County File: ANX234

Re: Karmen Line Addition

Review 1 comments:

Figure 4
Existing Traffic Conditions

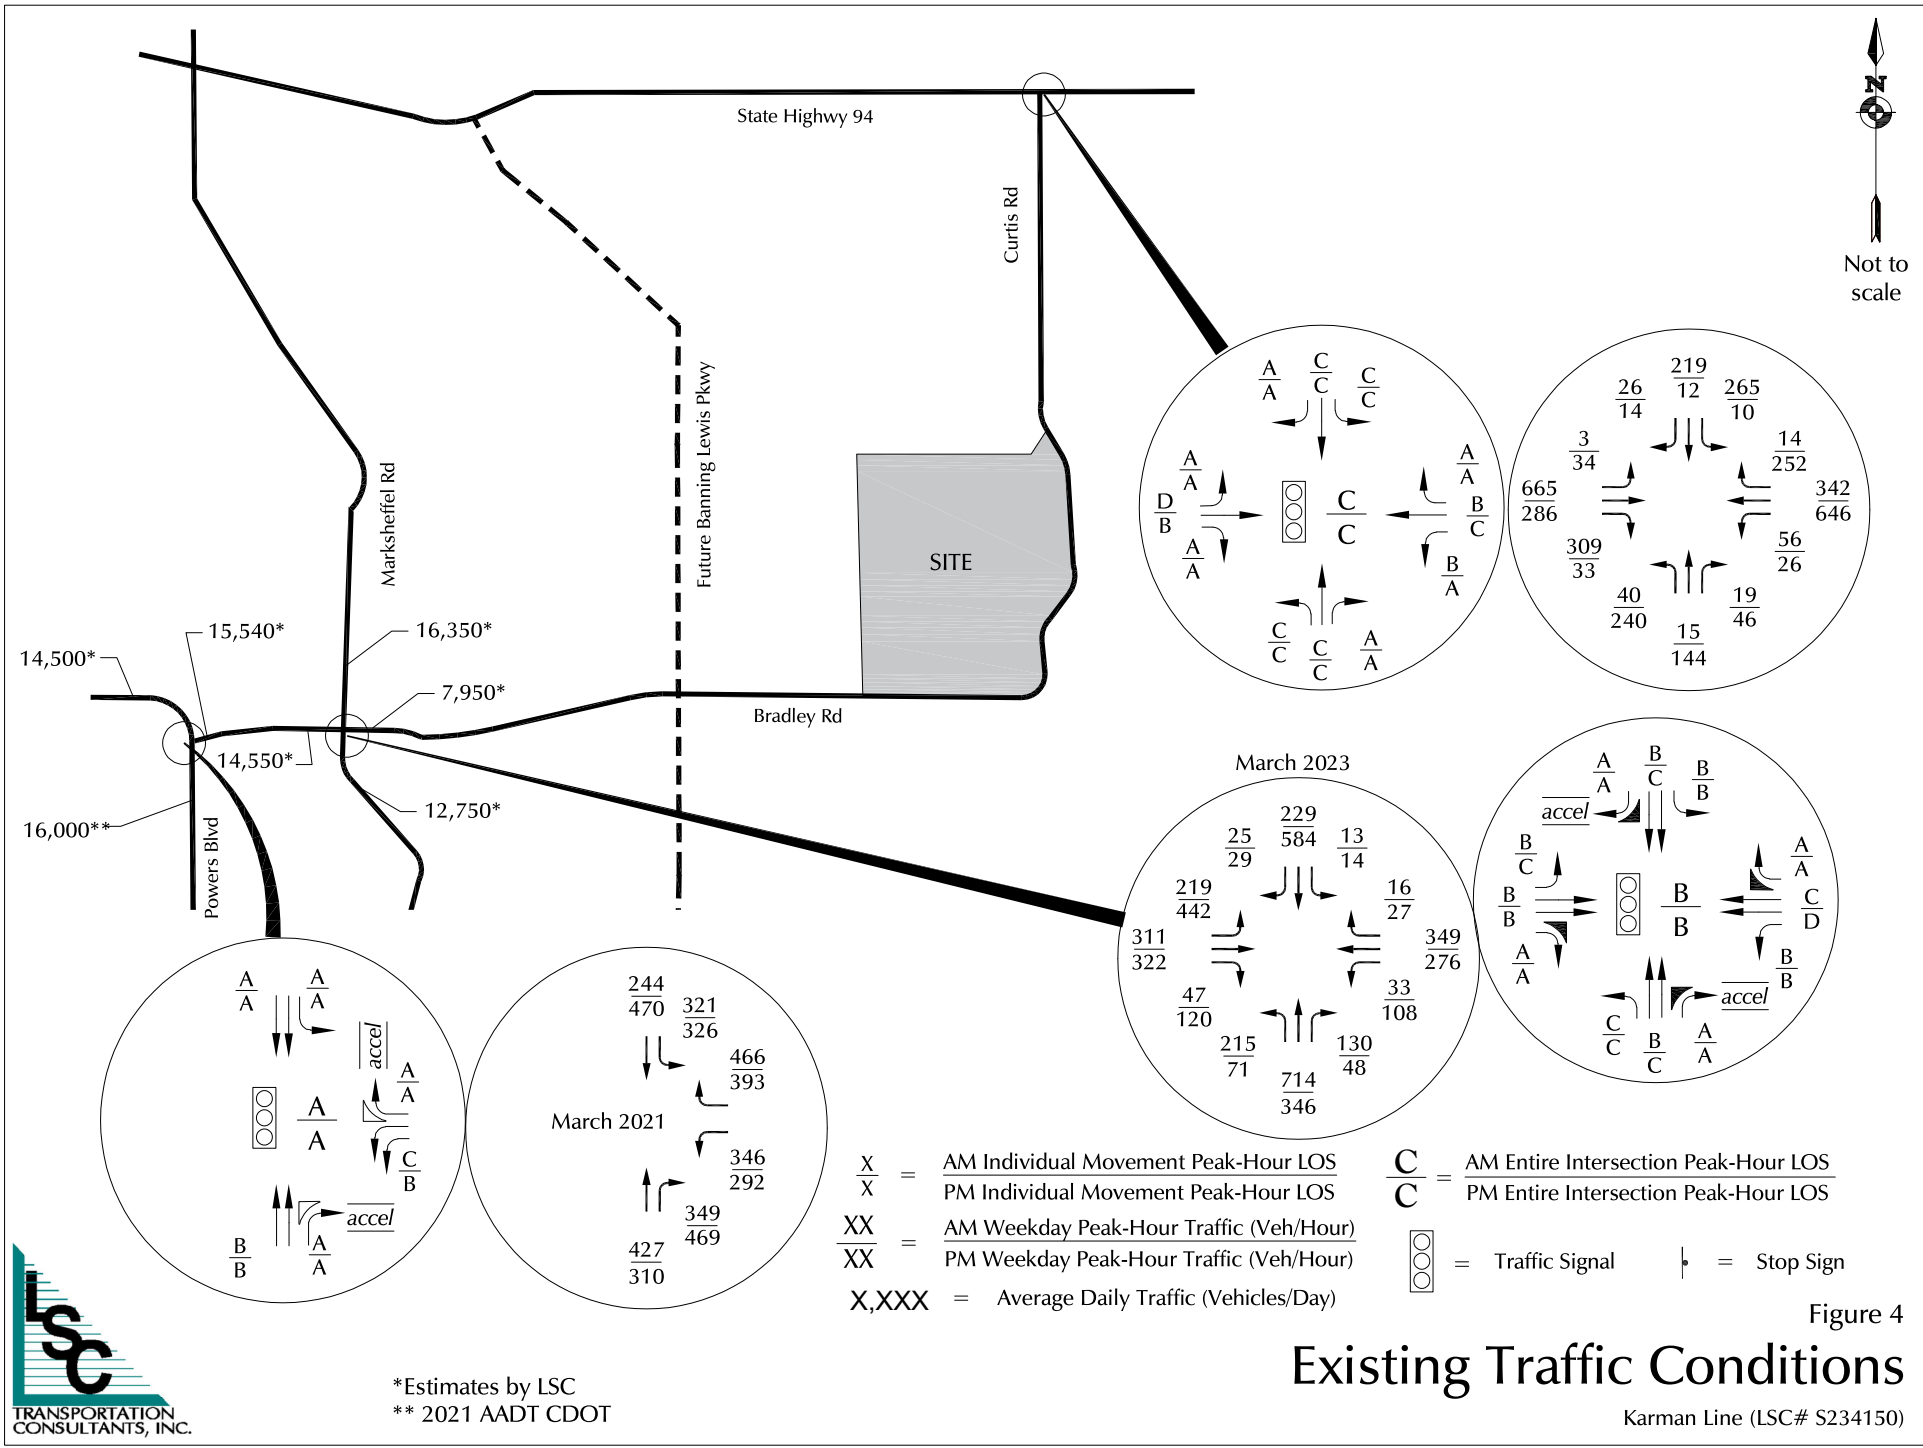
Transportation Memorandum: pages 2, 5, Figure 4, Figure 5

Figure 5
Directional Distribution

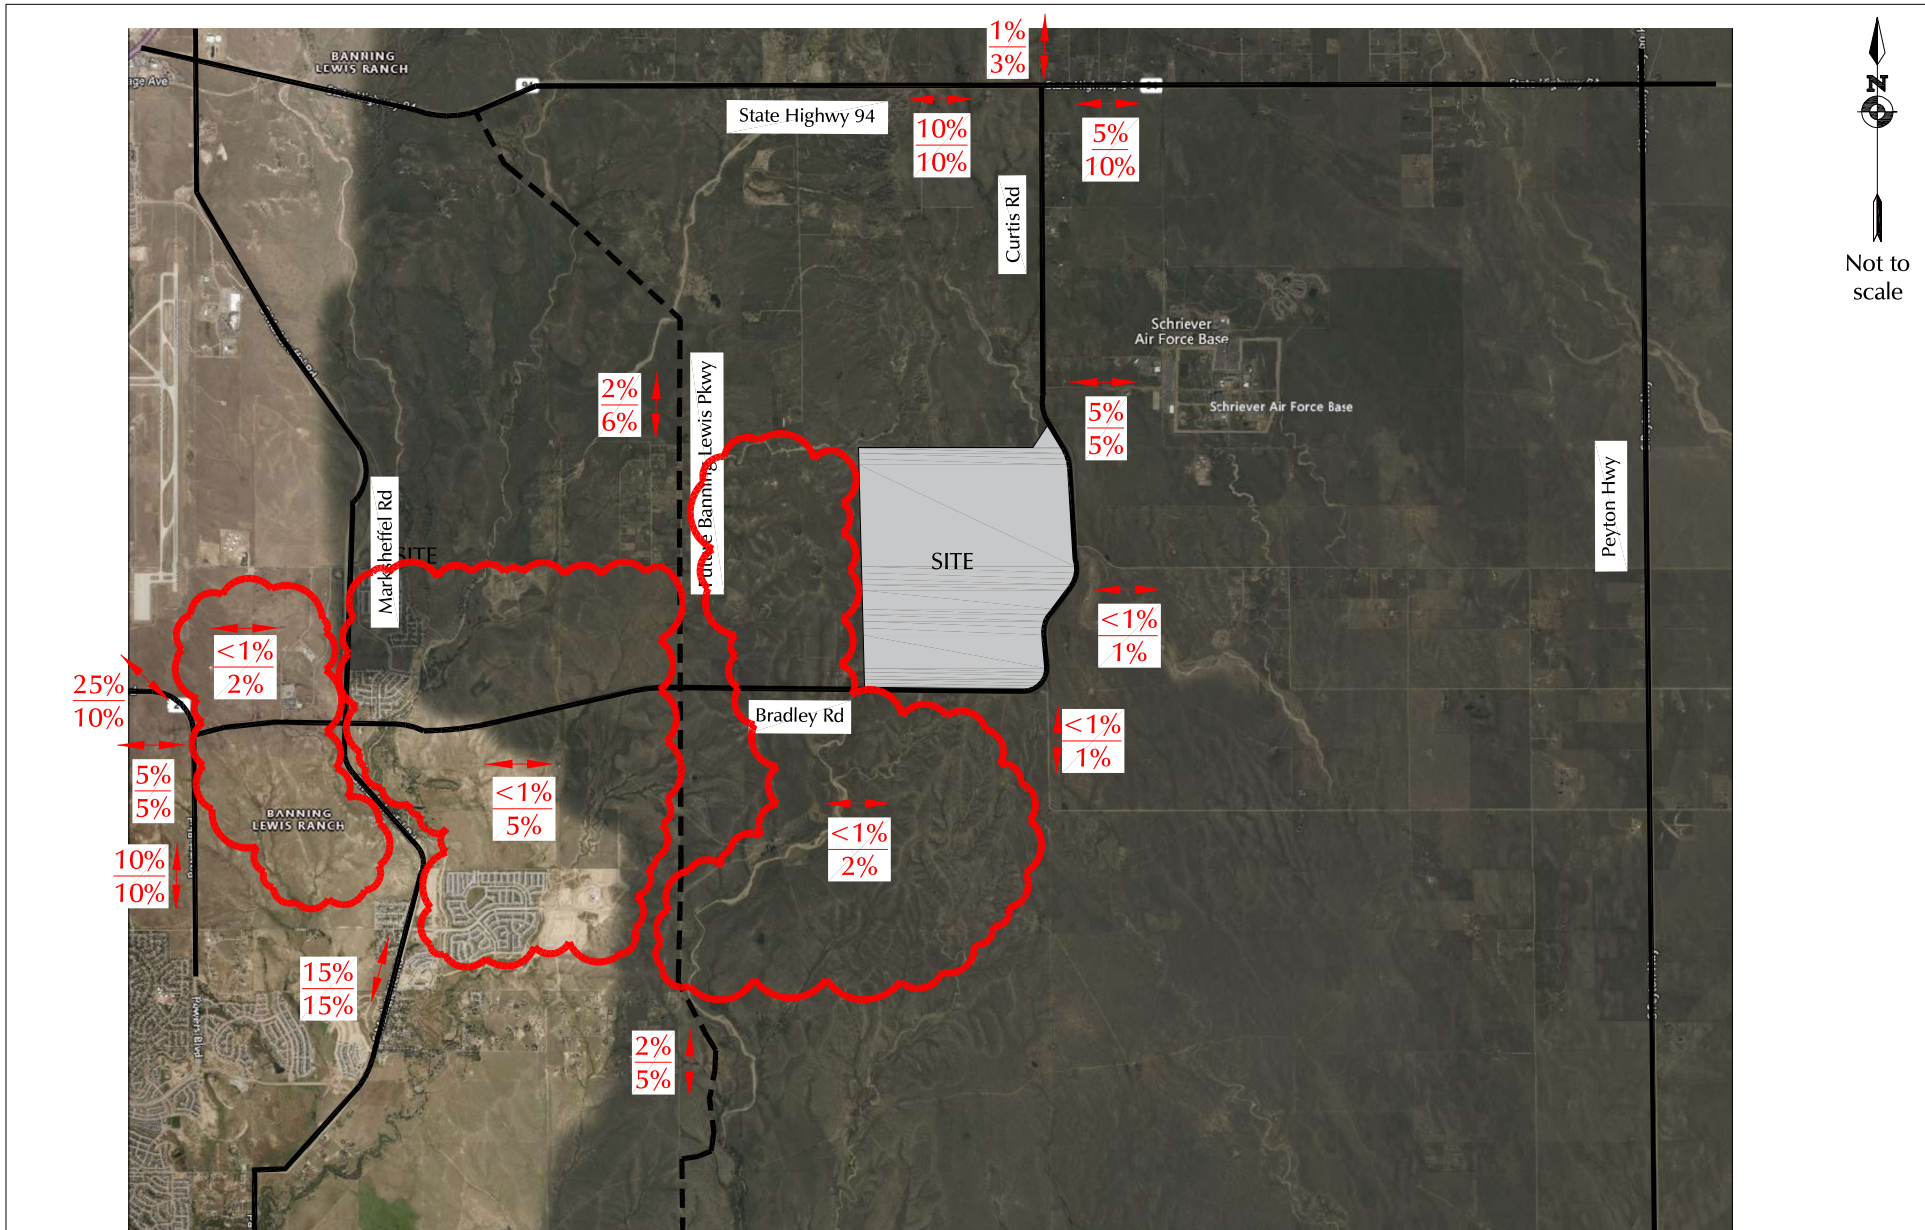
Verify that totals
← add up to 100%
(10-17% missing?)

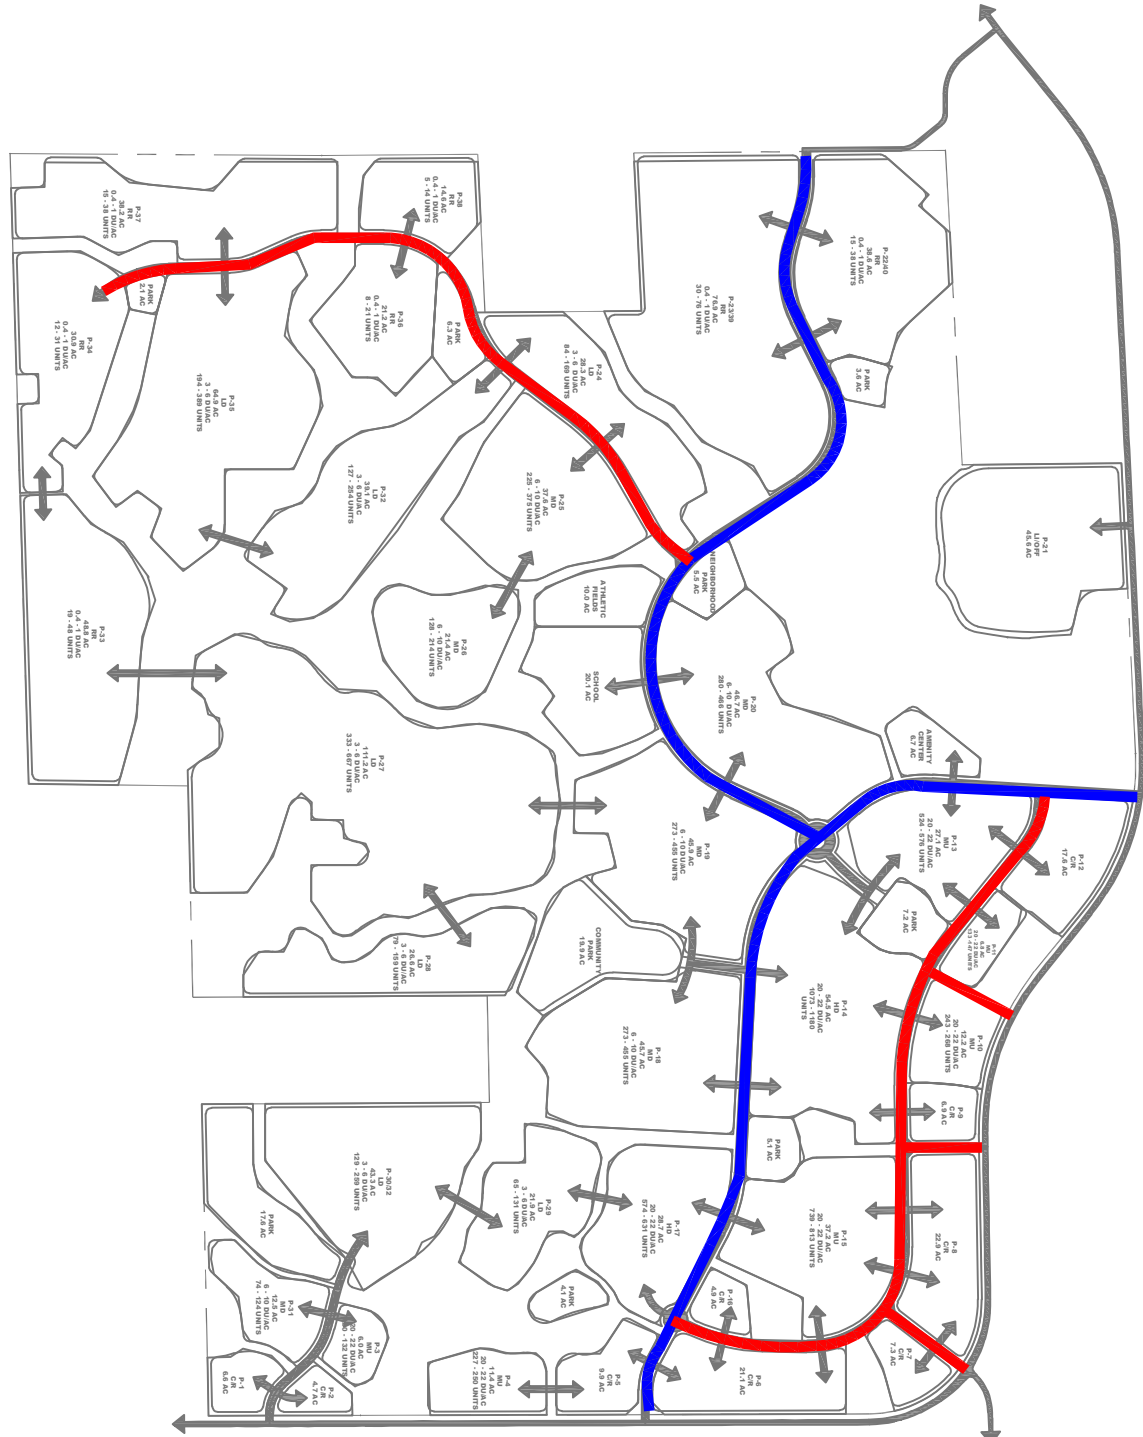
Please discuss any changes in the roadway classification of Bradley Rd and Curtis Road due to the developments traffic.
